# CITY OF ALBUQUERQUE

**Re: Premier Manufacturing Homes, Grading and Drainage Plan  
Engineer's Stamp dated 9-16-12 (M14/D012C1)**

Based upon the information provided in your submittal dated 9-17-12, the above referenced plan cannot be approved for Building Permit until the following comments have been addressed:

ENTRANCE DETAIL

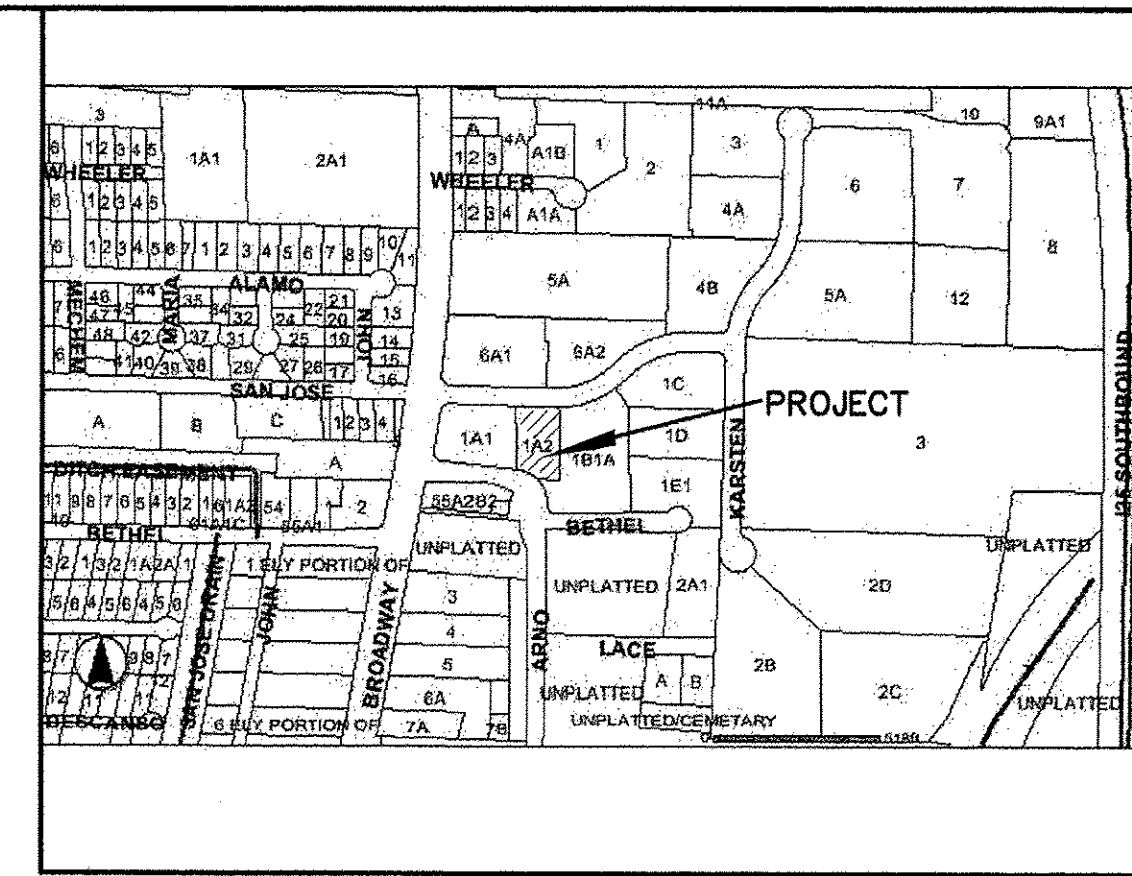
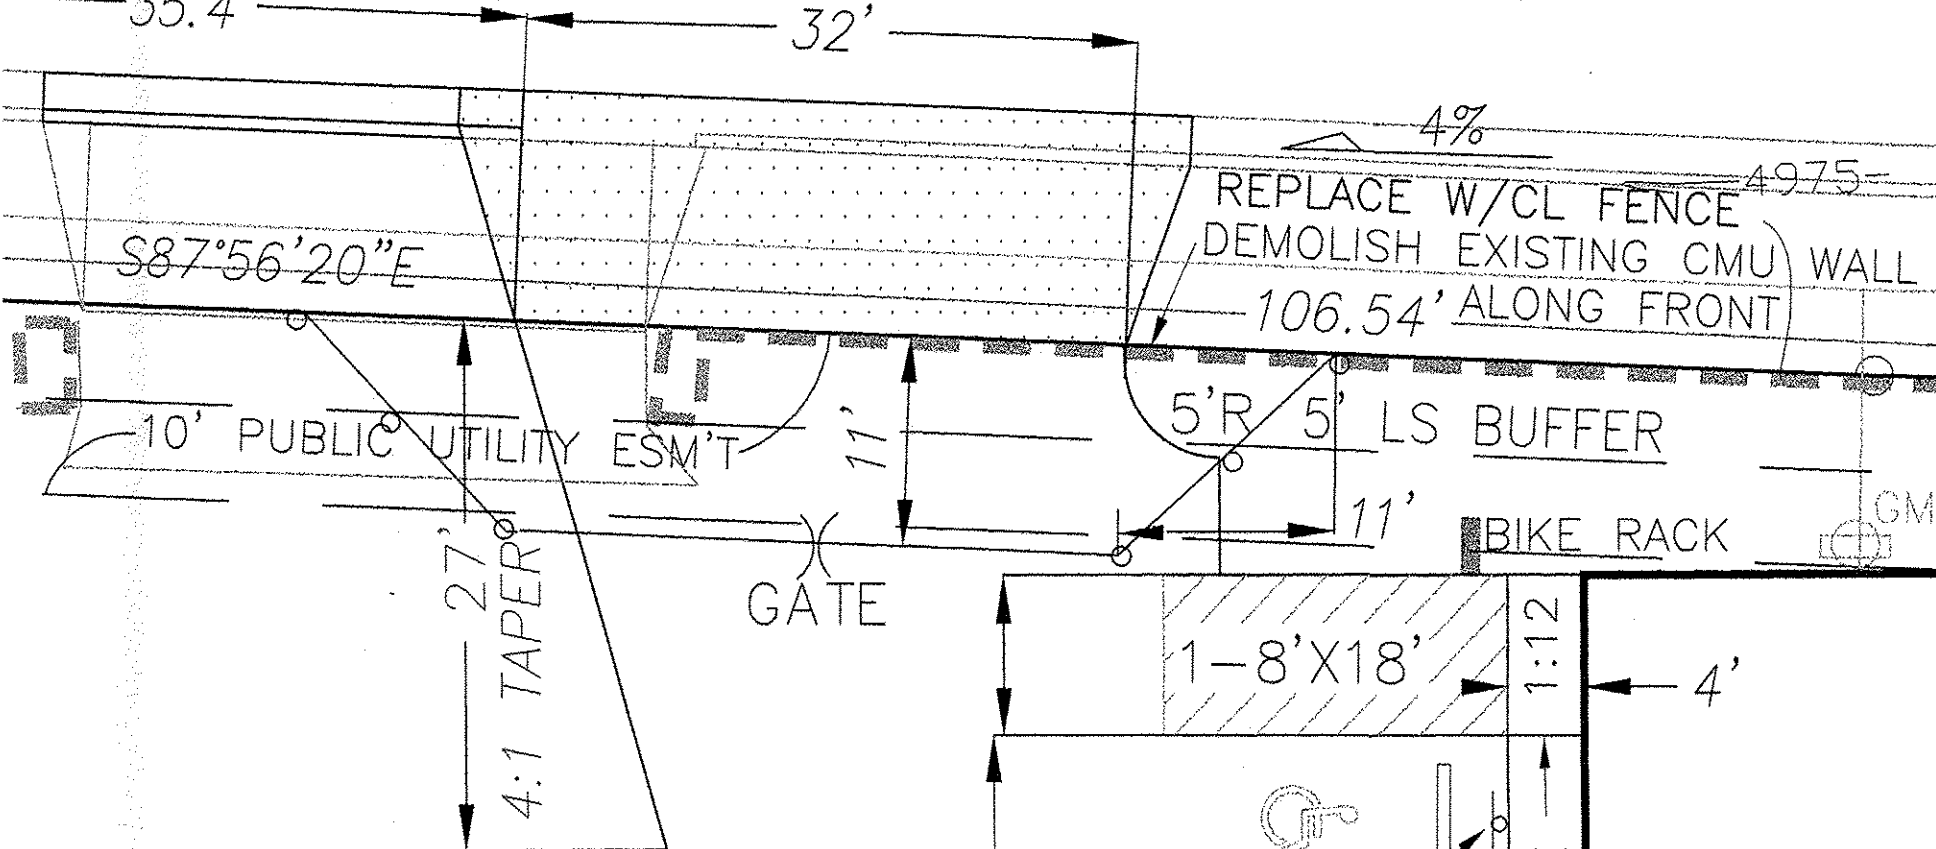
- Show grades at the proposed driveway to assure adequate water block is provided. Grade at the Eastern portion of the entrance may be too high due to proximity of the proposed handicap parking space. Provide spot elevations at four corners of the handicap parking area to assure ADA compliance.
- Since the proposed handicap space is the only handicap parking most likely has to be designated as Van handicap space. Therefore, the angle striped space to the north of the handicap will have to be increased. Please update your plan if the spacing will have to change.
- Provide proposed spot elevations along the property line to assure runoff does not pond against the existing retaining wall.
- Depress landscaping areas where possible.
